COTTAM SOLAR PROJECT– EN-010133

WEST LINDSEY DISTRICT COUNCIL – 20037171

ISSUE SPECIFIC HEARING 2 – ENVIRONMENTAL MATTERS- GENERAL

SUMMARY OF HEARING

Thorpe medieval settlement

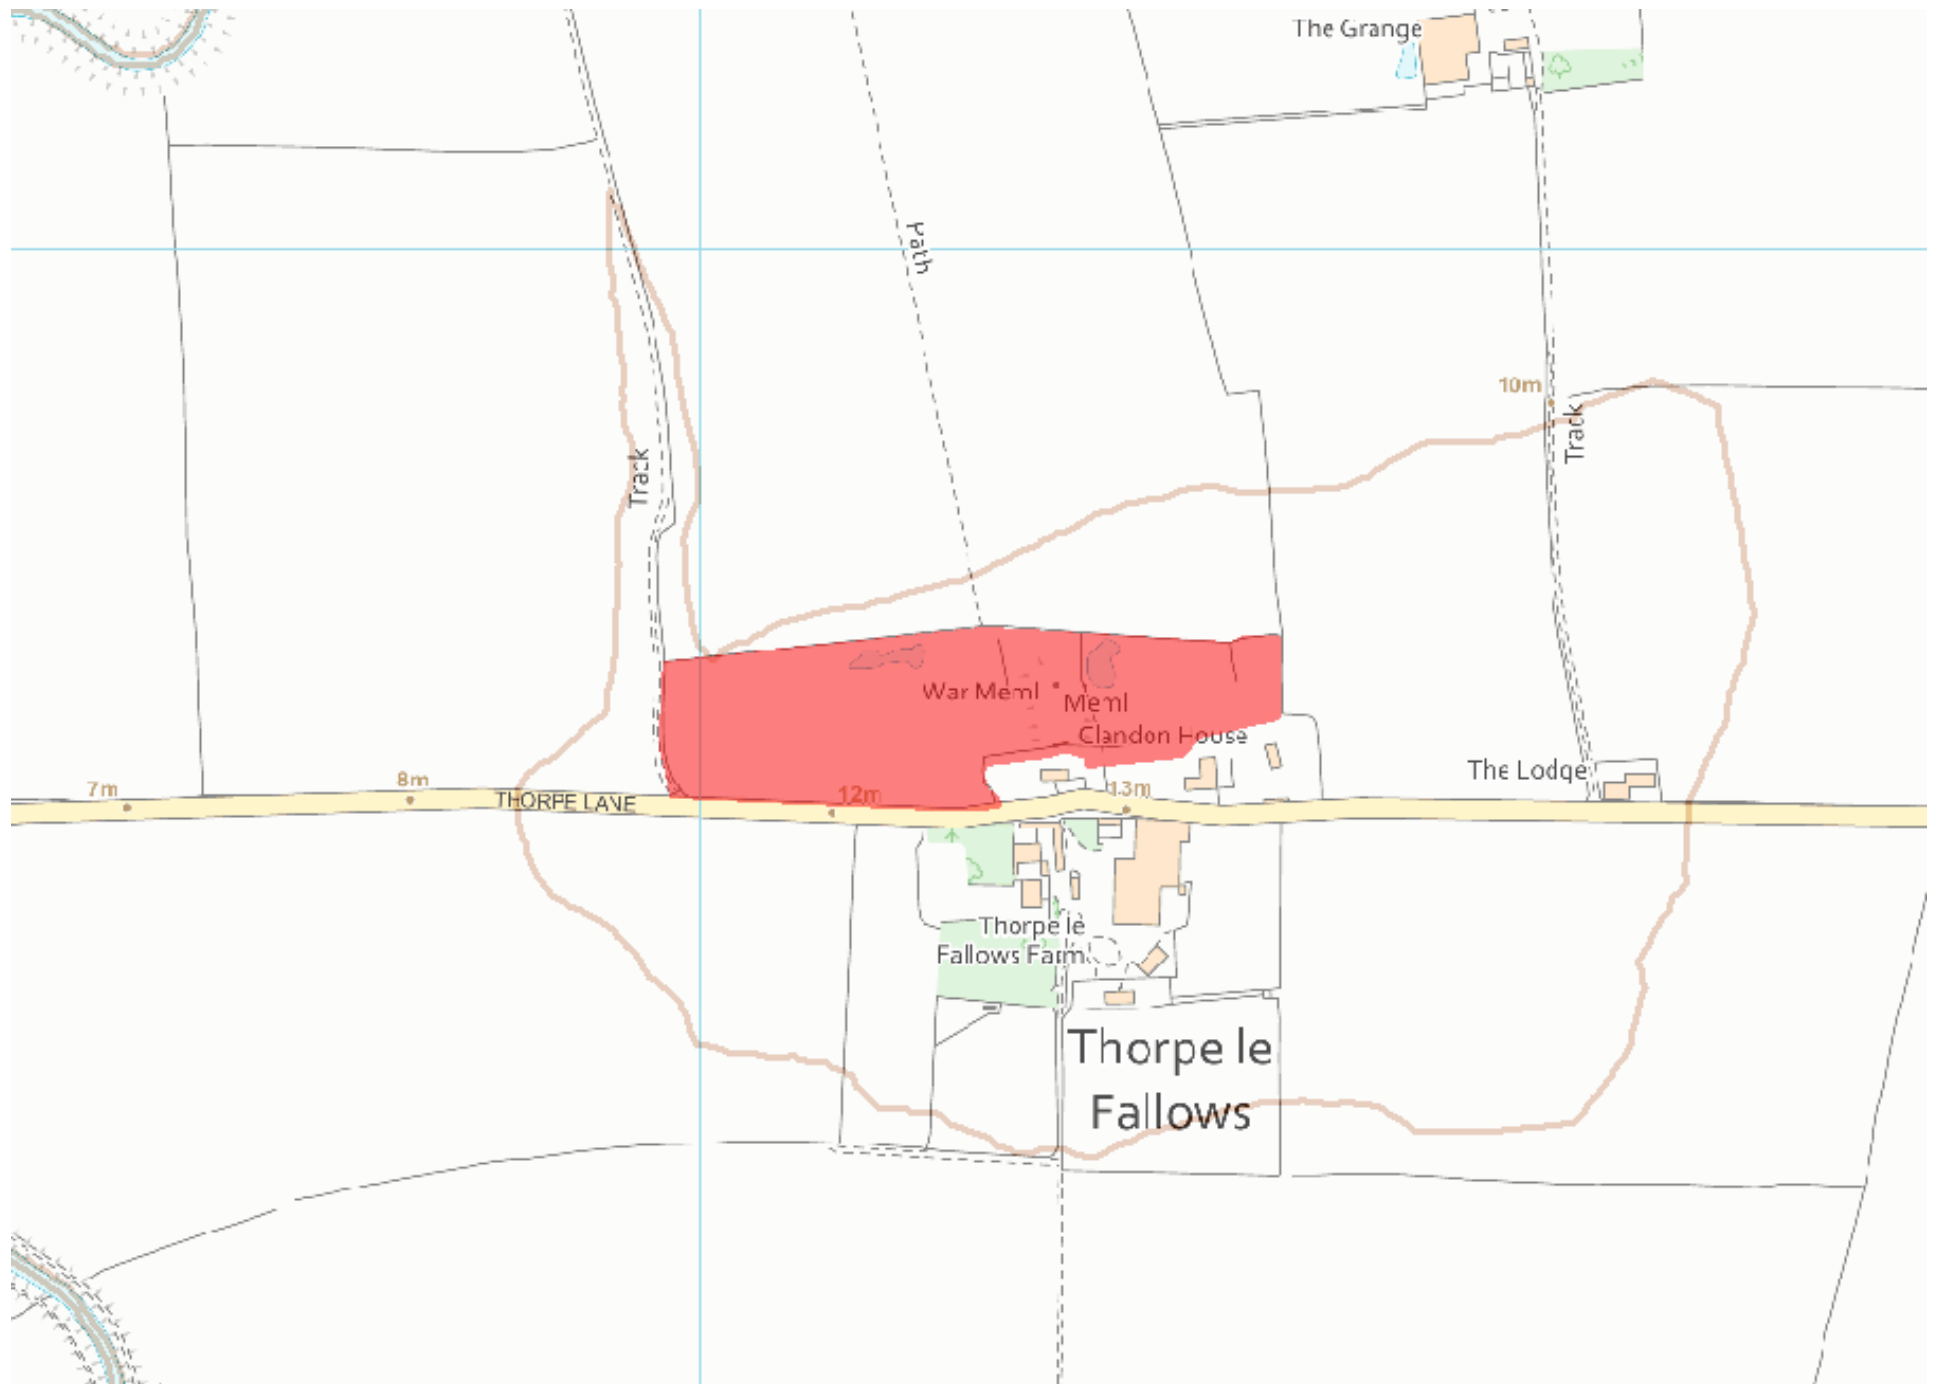
ITEM	MATTER	WLDC Comments
3. MAIN DISCUSSION POINTS		
	<p>The Historic Environment</p> <p>The effect on the significance of Thorpe Medieval Settlement Scheduled Monument (SM), including the setting, boundaries, the proximity of the solar arrays and mitigation, as well as the most up to date position with Historic England.</p>	<p>WLDC note the position of Historic England (as stated in their Relevant Representation (REP-065)) and concur with the comments made, and position adopted.</p> <p>The impacts of the proposed development upon the Thorpe Medieval Settlement (NHLE ref. 1016978) have been assessed in the applicant’s Environmental Statement to be ‘moderate adverse’, which is ‘significant’ in EIA terms. WLDC considers this impact to be a considerable level of less than substantial harm for the purpose of assessing the proposed development against paragraph 5.9.27 and 5.9.32 of NPS EN-1 (2023) in that such harm should be weighed against the public benefits of the proposal.</p> <p>WLDC note and concur with Historic England’s conclusion that the 50m buffer applied to the north of the Scheduled Monument is insufficient and does not address the impacts caused by the proposed development to the significance of the monument. Historic England have provided a recommendation that solar panels are removed between the Scheduled Monument and the former historic east-west boundary (as recorded on the historic map provided by</p>

ITEM	MATTER	WLDC Comments
		<p>Historic England in their Deadline 2 submission). Based upon the proportionately small area of land affected by this request, WLDC considers it a wholly reasonable solution to ensure statutory and policy requirements are satisfied.</p> <p>Should the applicant decline to amend the proposed development in the manner requested by Historic England, WLDC consider this to be an issue upon which the application should be refused development consent.</p>
	<p>The potential for disturbance to archaeological remains, in particular during the construction phase; and</p> <p>The approach set out the Archaeological Mitigation Written Scheme of Investigation.</p>	<p>As the local authority responsible for archaeology, WLDC defer to Lincolnshire County Council on such matters.</p>
	<p>Agriculture and soils</p>	
	<p>Written Ministerial Statement (March 2015)</p>	<p>The Written Ministerial Statement (March 2015) has not been revoked and remains an important and relevant matter for consideration in determining the Cottam Solar Project under section 105 of the Planning Act 2008.</p> <p>The publication of the update National Policy Statement EN-3 (to be ratified by Parliament early 2024) has the effect of providing updated policy with regard to the impact of solar farm development on agricultural land classification and land type. WLDC acknowledge that this updated policy must be read in context with the Ministerial Statement and provides the most recent policy where any conflicts between the two arise.</p> <p>WLDC maintain that both the Ministerial Statement and the updated NPS both require solar projects to be sited on poorer quality land and that applicants are required to explain their choice of site, noting the preference for development to be on suitable brownfield, industrial and low and medium grade agricultural land.</p> <p>WLDC also note the Applicant's clarification that the environmental assessment does not rely upon the grazing of livestock.</p>
